Charlotte Department of Transportation

Memorandum

Subject: Rezoning Petition 08-075: Located on the north side of East Woodlawn Road between Park Road and Halstead Drive
(revised 9/19/08)

PROJECT NO. FFD-06020
 FILENAME: FFD06020-R21
 DESIGNED BY: CSS
 DRAWN BY: CSS
 SCALE: 1" = 40'
 DATE: 10-14-2008
 SHEET NO. **TD-1**

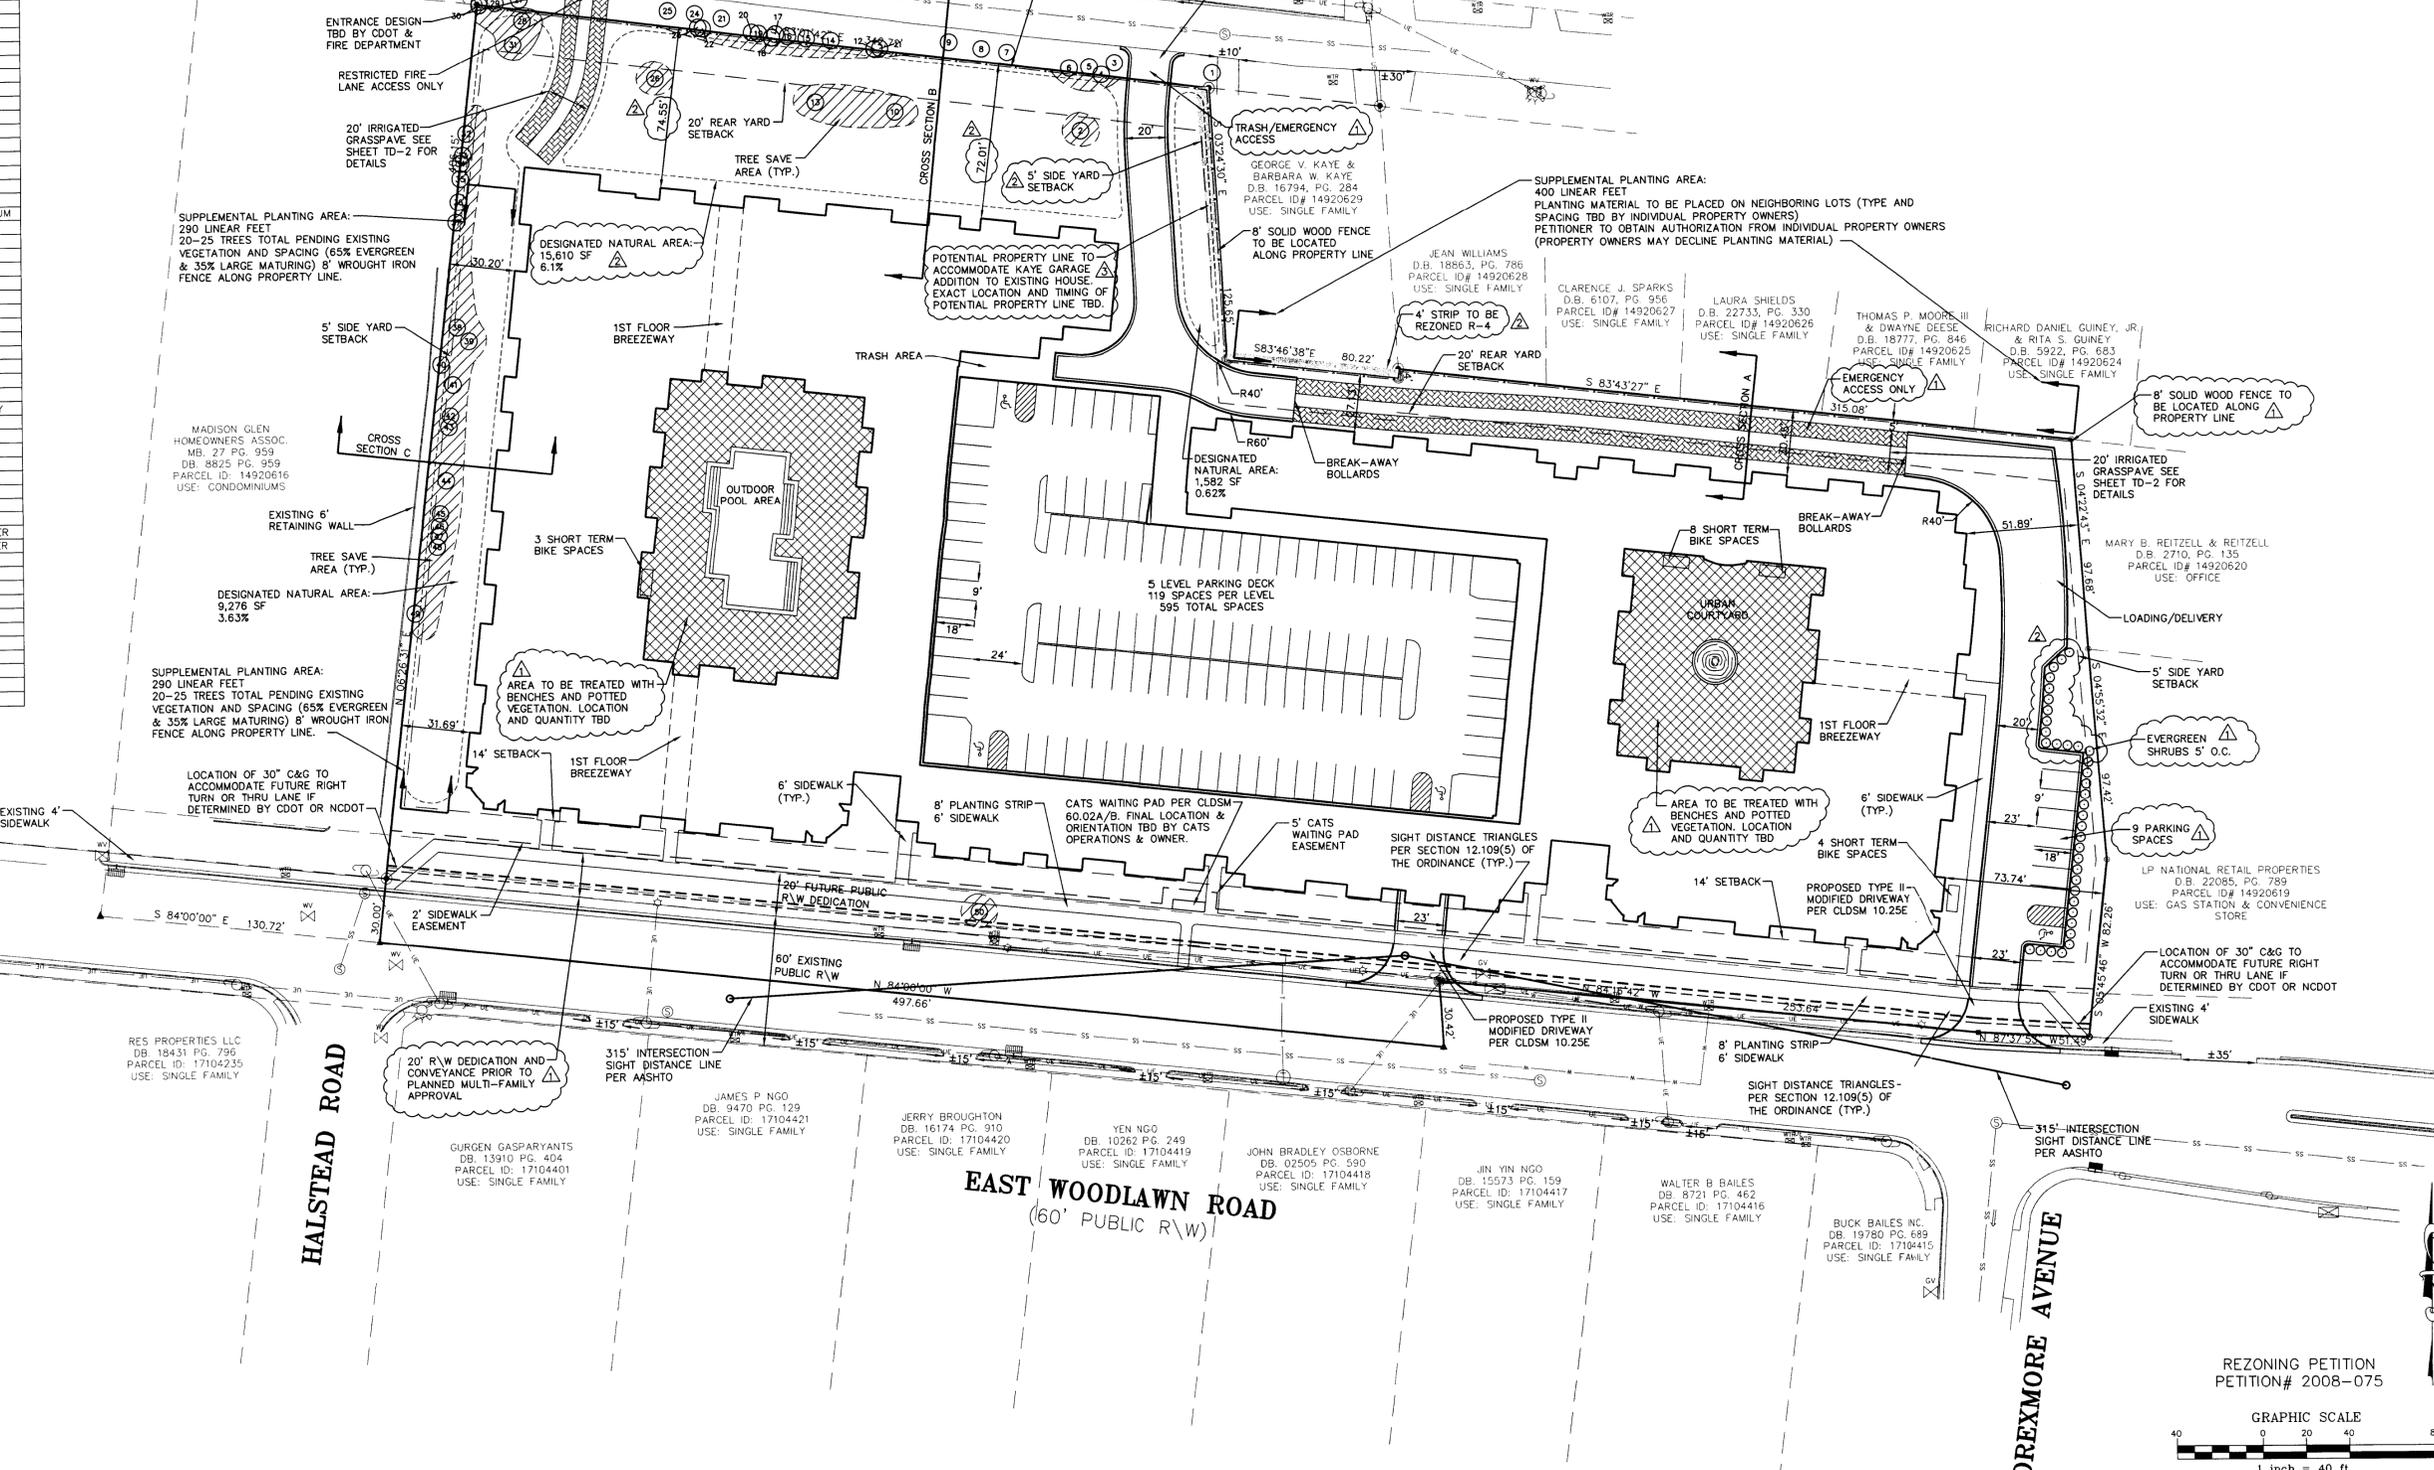
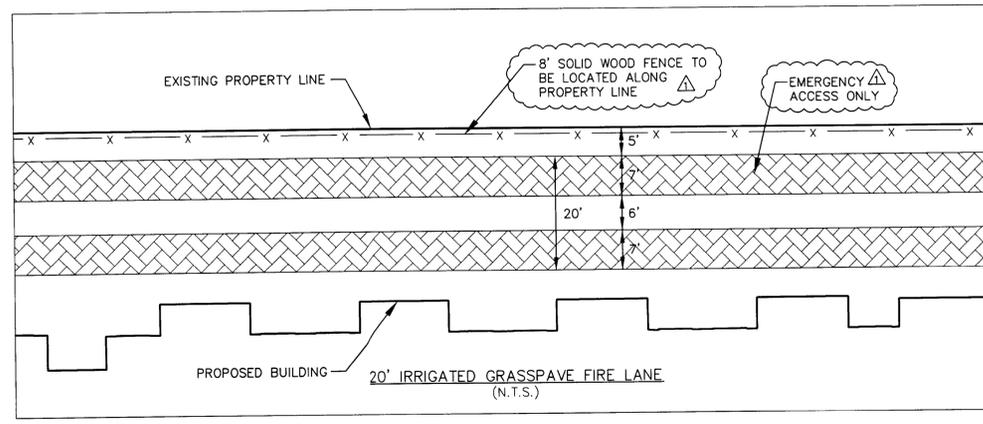
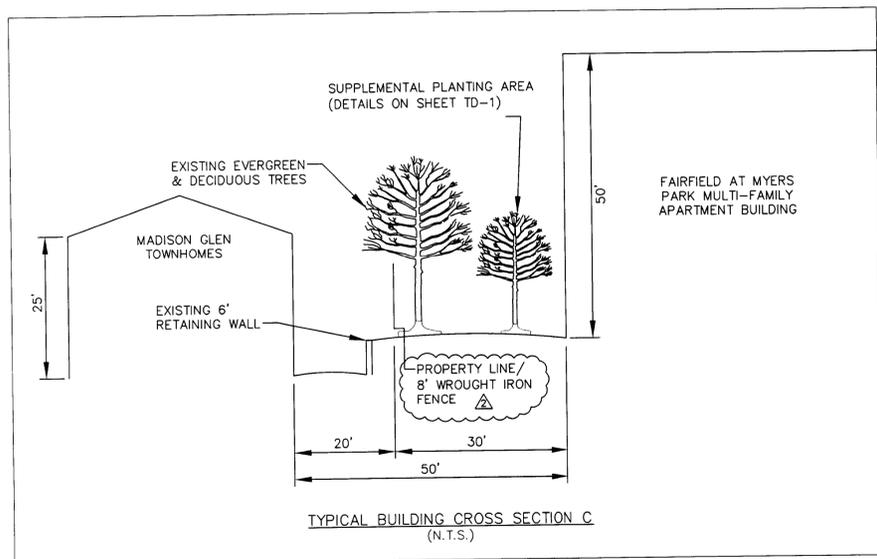
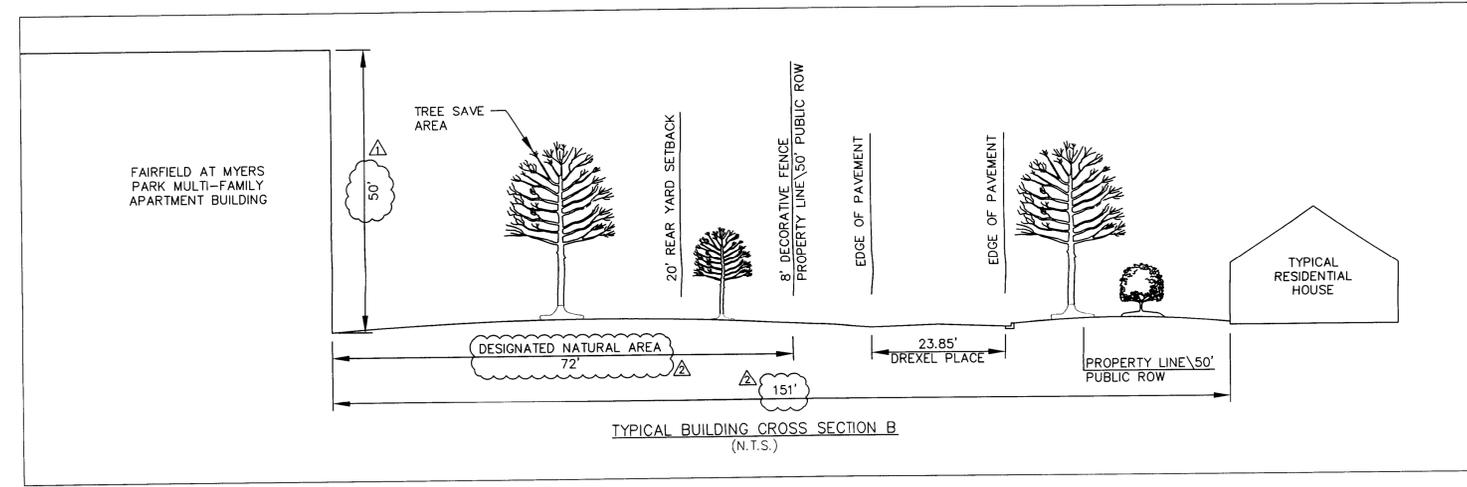
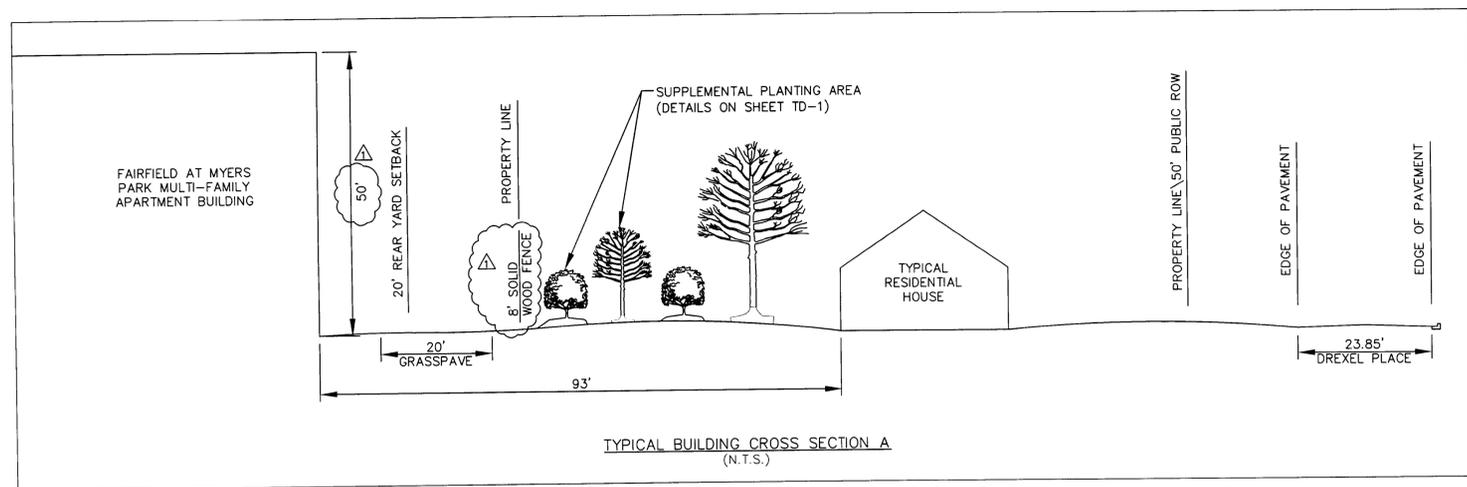
1. The subject site is located in a Center. The preferred block length in a Center is 500 feet and a maximum block length of 650 feet. The current block length on East Woodlawn Road between Park Road and Waterbury Drive exceeds 1,500 feet. This site has approximately 750 feet of frontage along East Woodlawn Road. Both existing and new developments need

to be connected by streets, bikeways and pedestrian systems to reduce vehicle miles of travel (TAP Policy 2.9.4). For these reasons a new public street is needed in this location between East Woodlawn Road and Drexel Place. We recommend that the new street have a curvilinear alignment along the center of the property. *(Previous review comment)*

2. The new street described above is to be designed and constructed to the Local Residential Street-Wide (includes on-street parking that can be recessed) cross section in accordance with the adopted Urban Street Design Guidelines (USDG). This cross section includes 10-foot travel lanes, 7-foot parking lanes, 8-foot planting strips, and 6-foot sidewalks. *(Previous review comment)*

3. Parking deck access needs be located along the required new street and not on East Woodlawn Road as currently shown. *(Previous review comment)*
4. New curb/gutter, planting strip (8'), and sidewalk (5') along Drexel Place are required to be constructed by the developer. The sidewalk can meander to preserve/minimize the impact to existing trees and the existing 6-foot tall wood fence, keeping at least 6 feet away from the new curb/gutter. The site plan needs to show all required items. A waiver of these items may be requested through subsequent building permit phases. *(Previous review comment)*
